Application No: LU/217/20/HH
Site Address: 34 Pier Road Littlehampton BN17 5LW
Description of works: Rear extension & outbuilding.

Thank you for your internet representation made on 1st September 2020 which has been recorded as an objection with the comments as follows:

Roofline

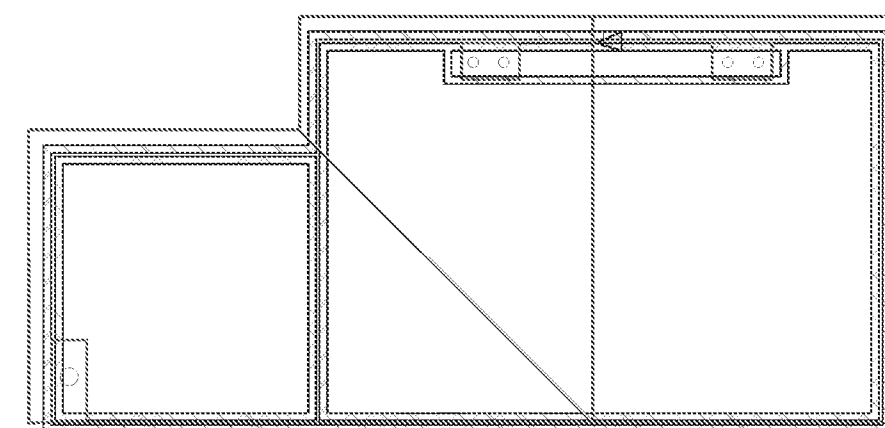
I am objecting only to the height of the chimney in the rear extension. It is likely that, if windy, the smoke will drift into our windows on the first and second floors of our house.
